Penrith Glass Beneficiation Project SSD-5267 – EPA Comment and Recommended Conditions of Consent

The EPA has reviewed the Benbow Environmental "*Environmental Impact Statement for Glass Recovery Services 126 Andrews Rd, Penrith*" May 2013 (the EIS) and provides comments as outlined in Attachment 1.

SSD 5267 EPA Comments

Figure 1-4: Site Layout

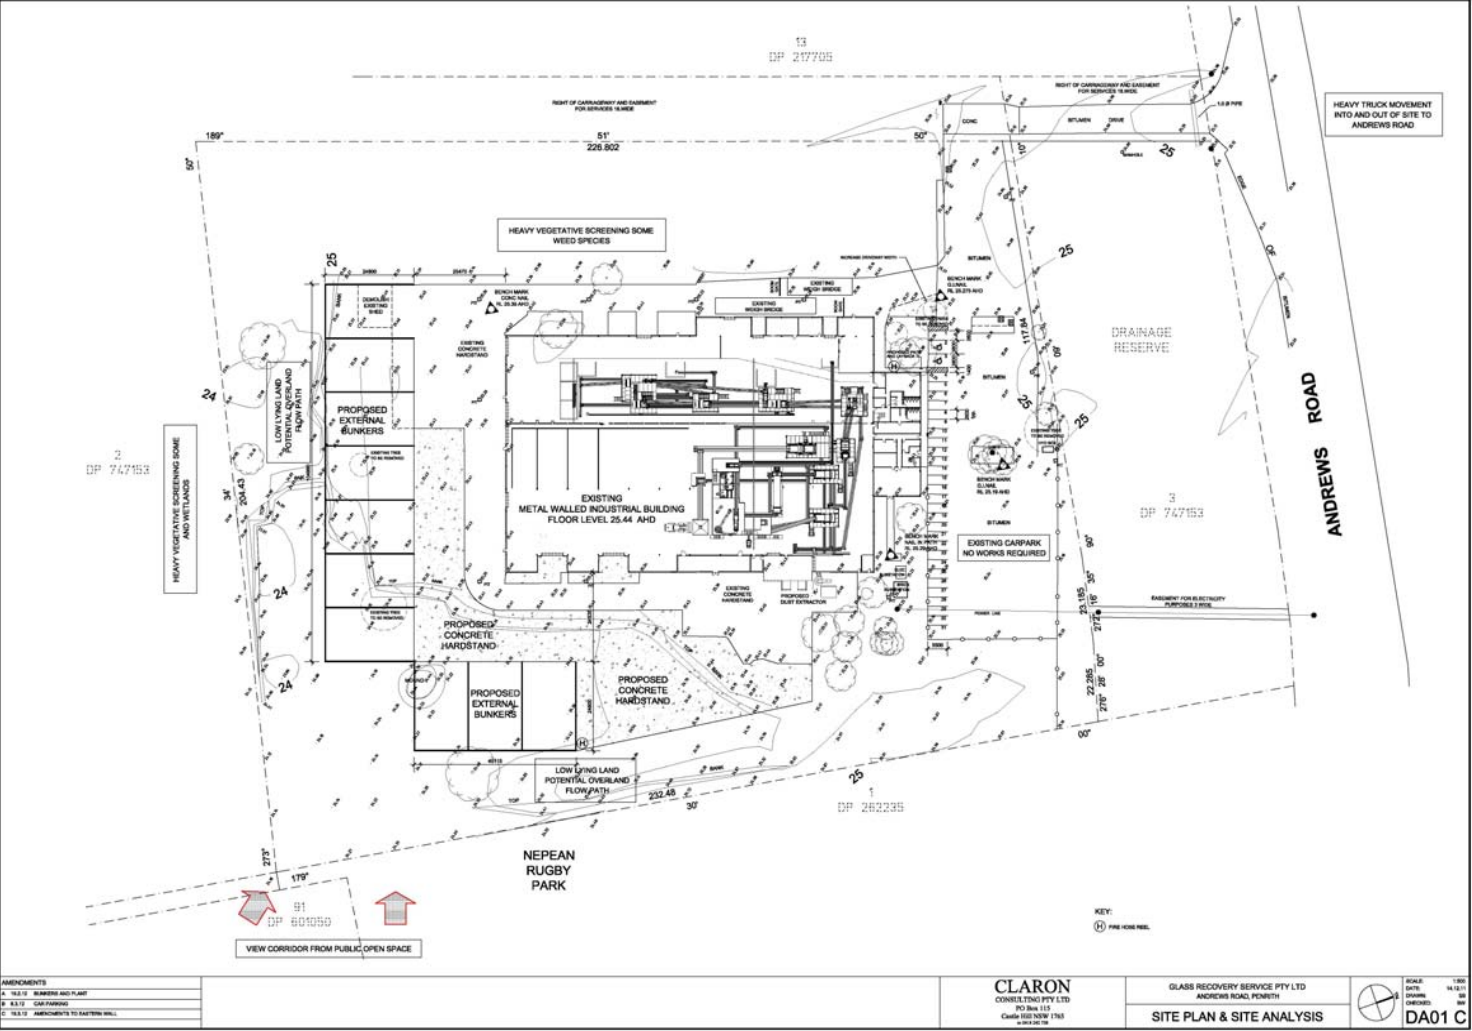
The dust baghouse is currently installed externally.

Recommendation: As the NIA modelling includes the dust baghouse being installed internally, this should be moved in to the factory.

126 ANDREWS ROAD PENRITH WETLAND & CONCRETE HARDSTAND DESIGN

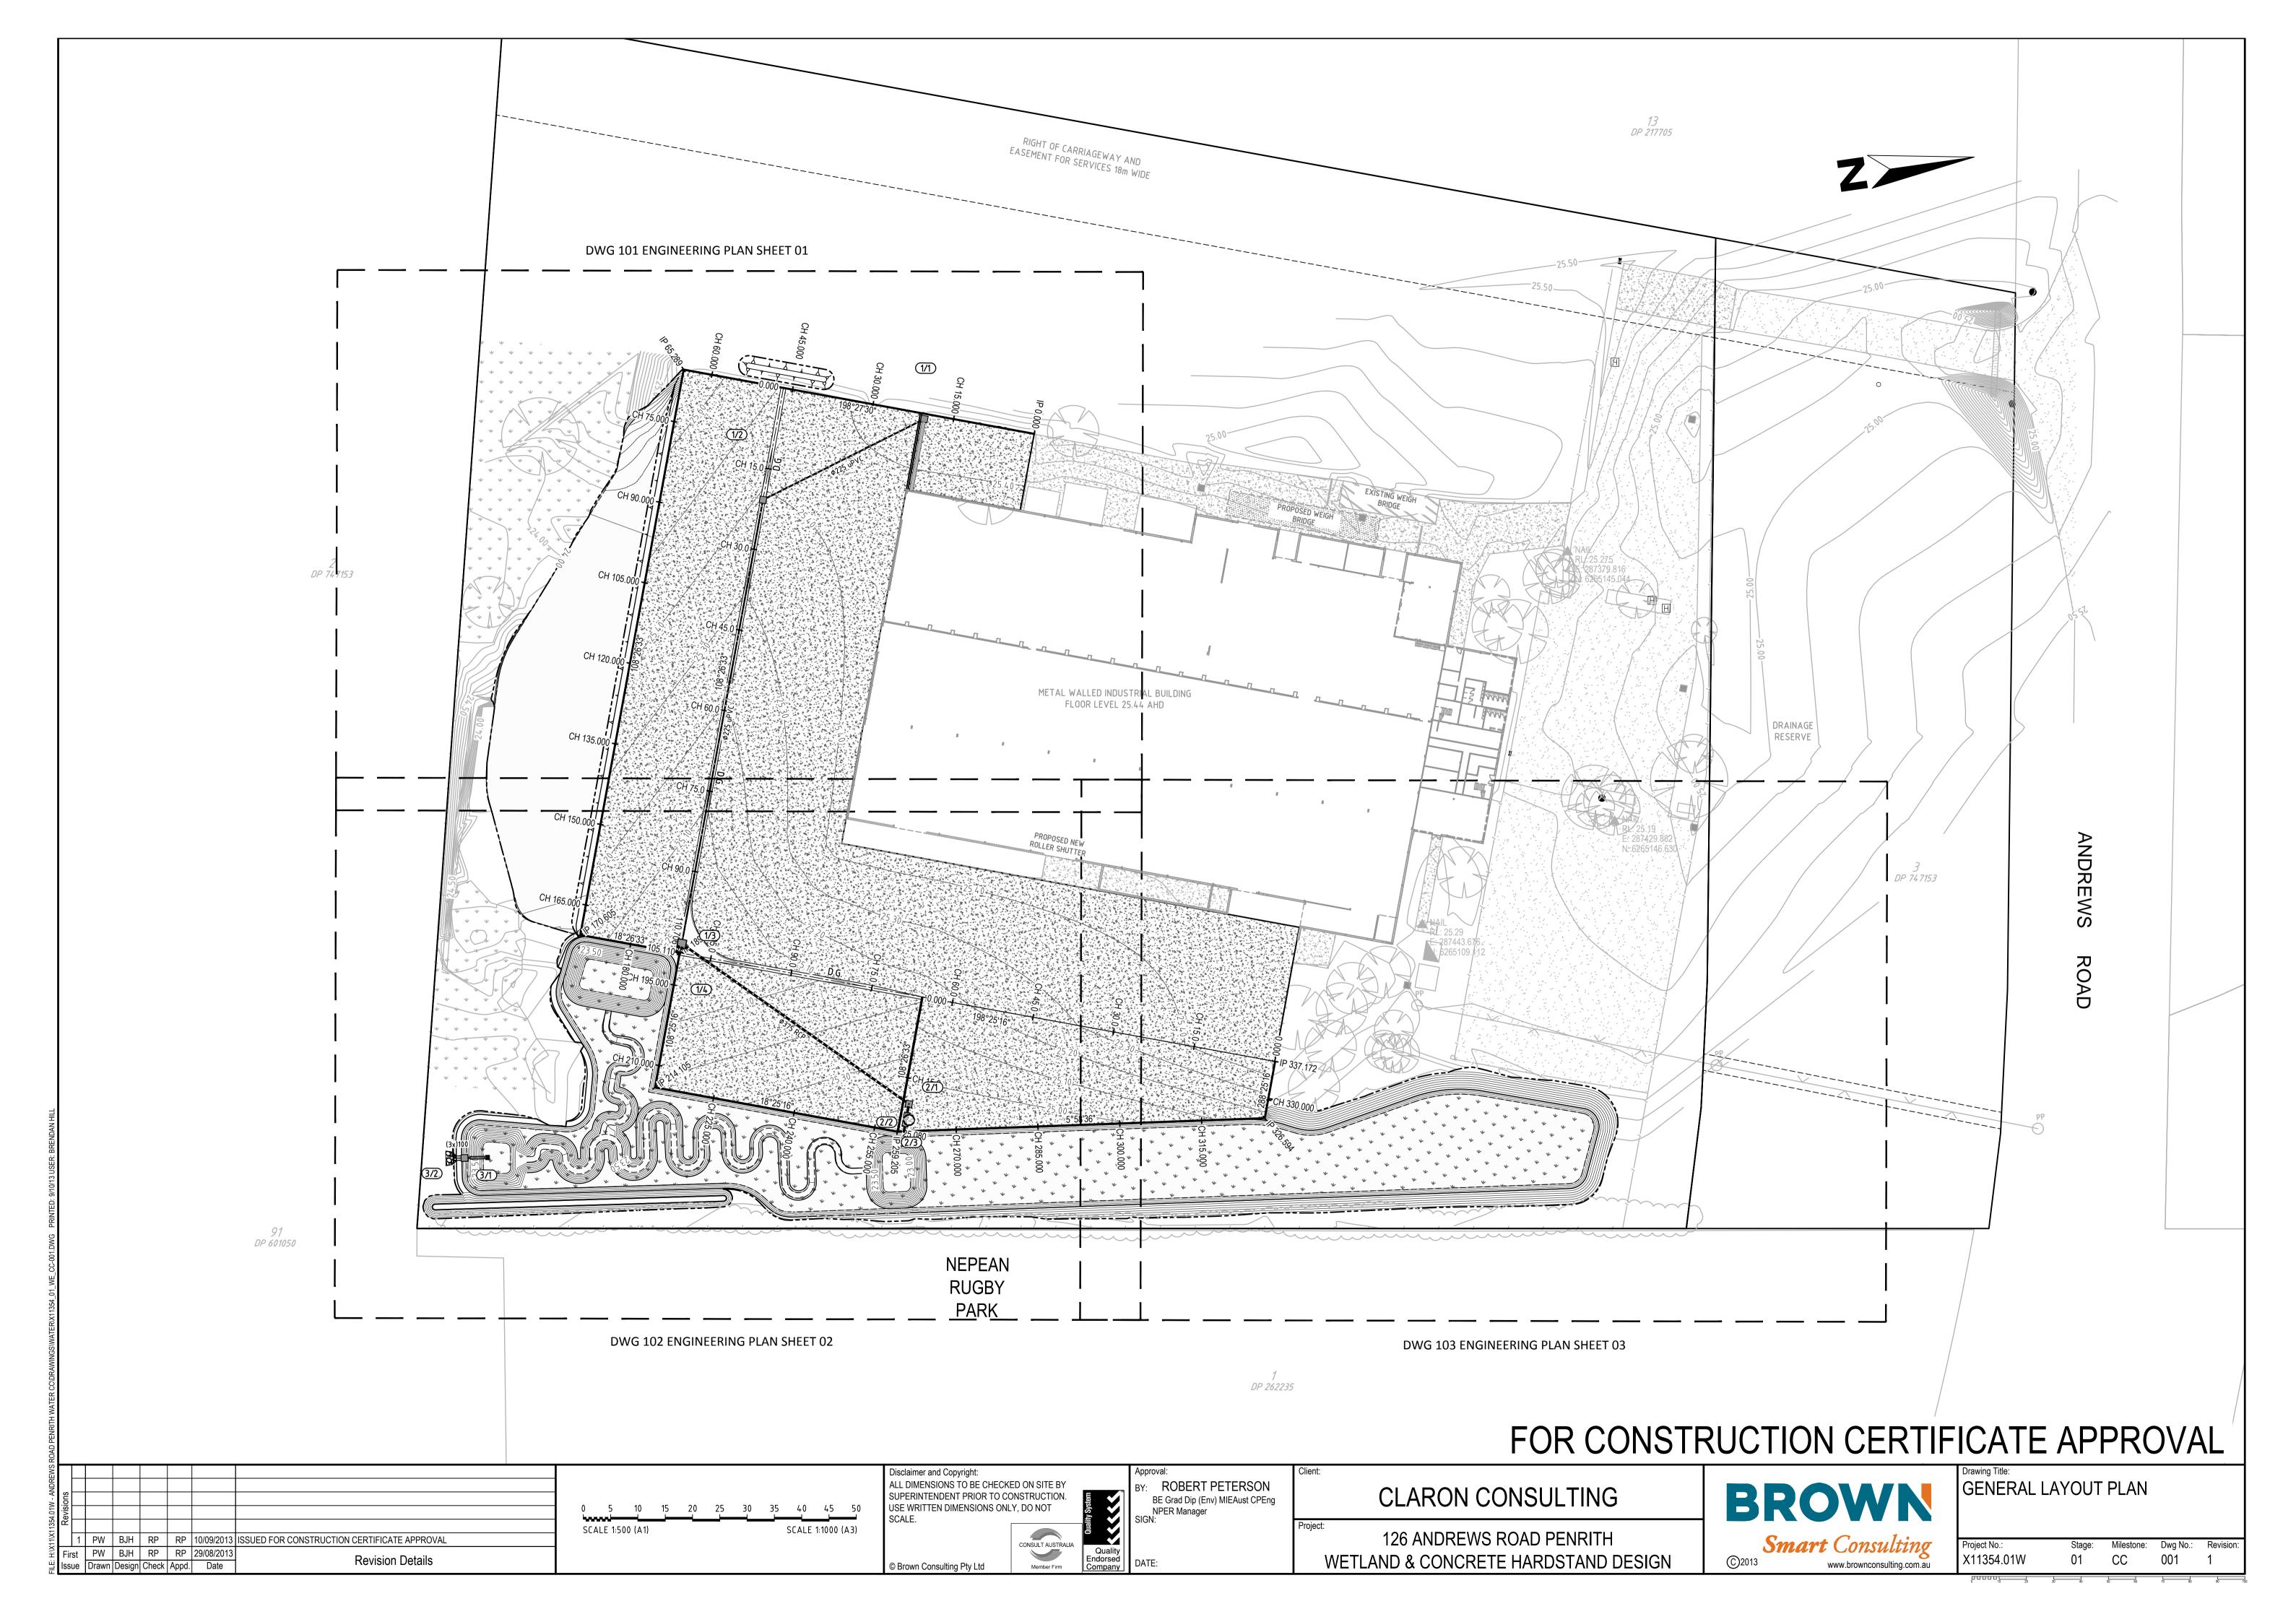
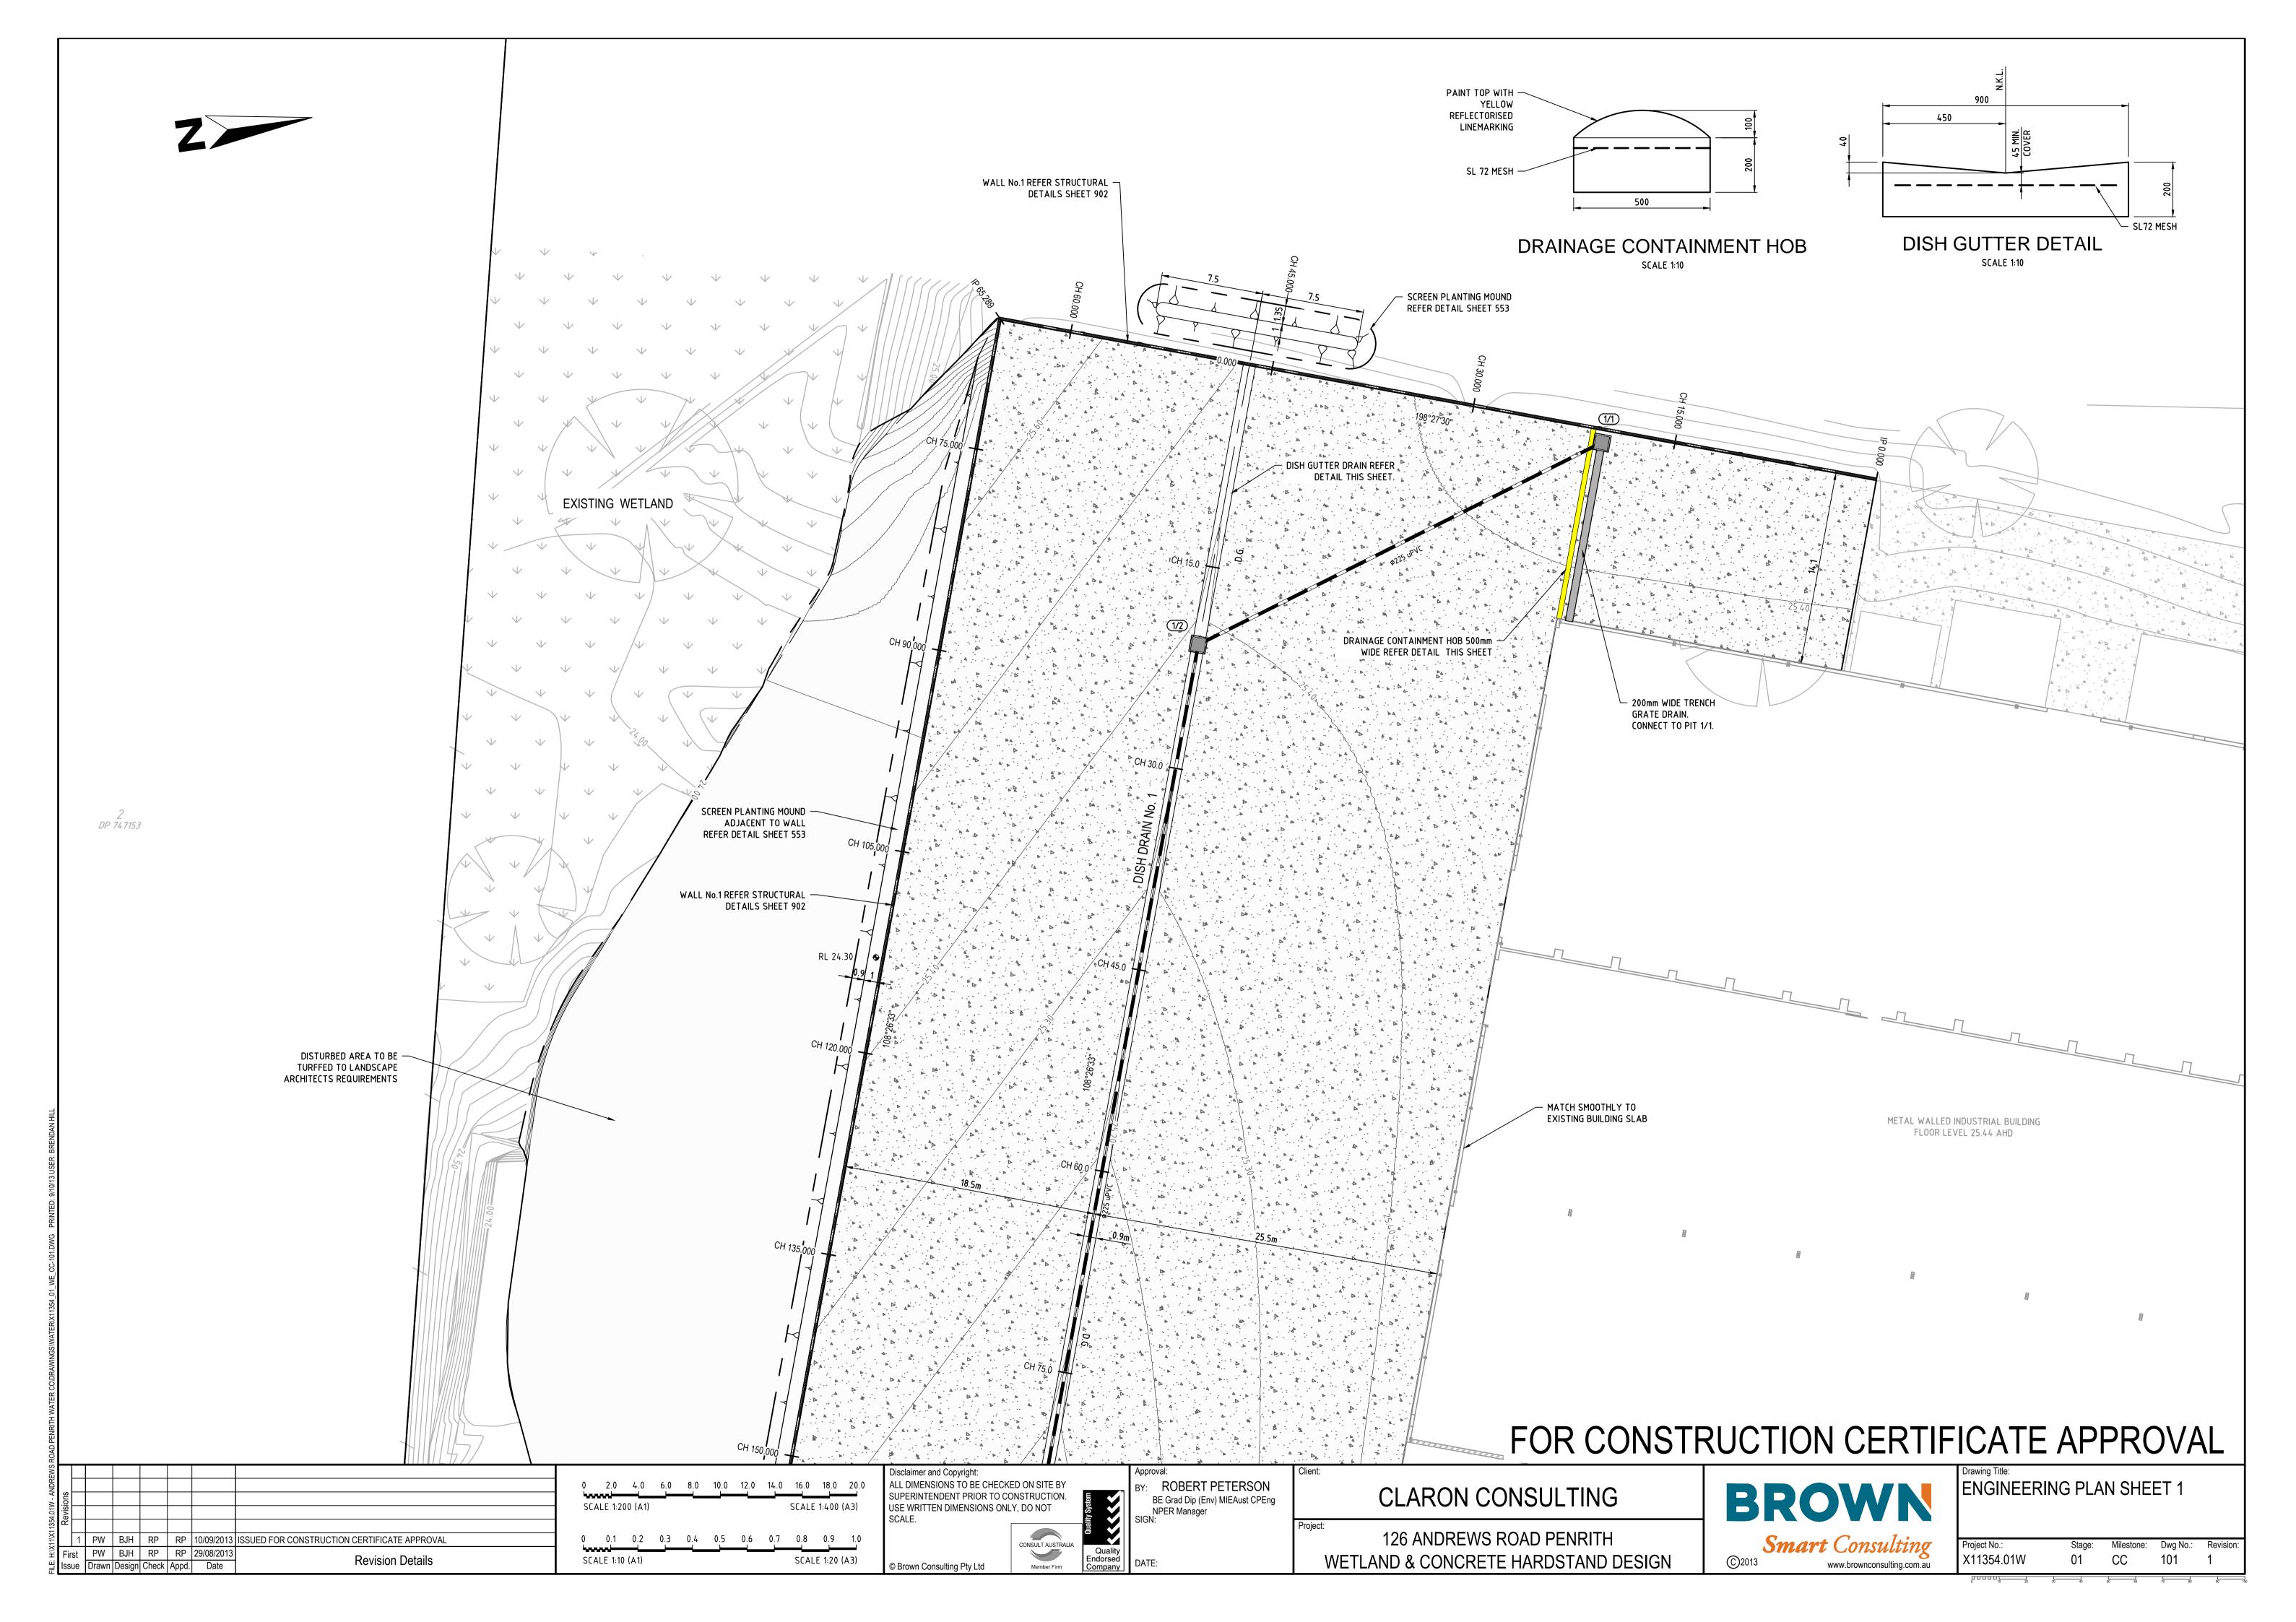
The external storage bays are proposed to be constructed within a floodplain. To maintain flood storage volume the proposal has designed 1 in 100 floodwaters to surcharge back in to these external bunkers.

During the review of the draft EIS, the EPA expressed concerns that glass cullet could potentially be carried out of the storage bays during flooding. The applicant subsequently provided the EPA with correspondence

entitled *Brown Smart Consulting X11354 EPA letter Rev01 17 May, 2013* that committed to the installation of floodwater containment bunds around the storage bay area, in order to ensure that all water would discharge from this area via the CDS interceptors. This correspondence was provided as a revision of the *Brown Smart Consulting X11354.W* referred to in the EIS.

Recommendation: The EPA requests the assessment be updated to include the advice of 17 May 2013. The EPA will require the installation and maintenance of floodwater containment bunds around the storage bay areas to ensure that all water, including floodwaters would discharge via the CDS interceptors.
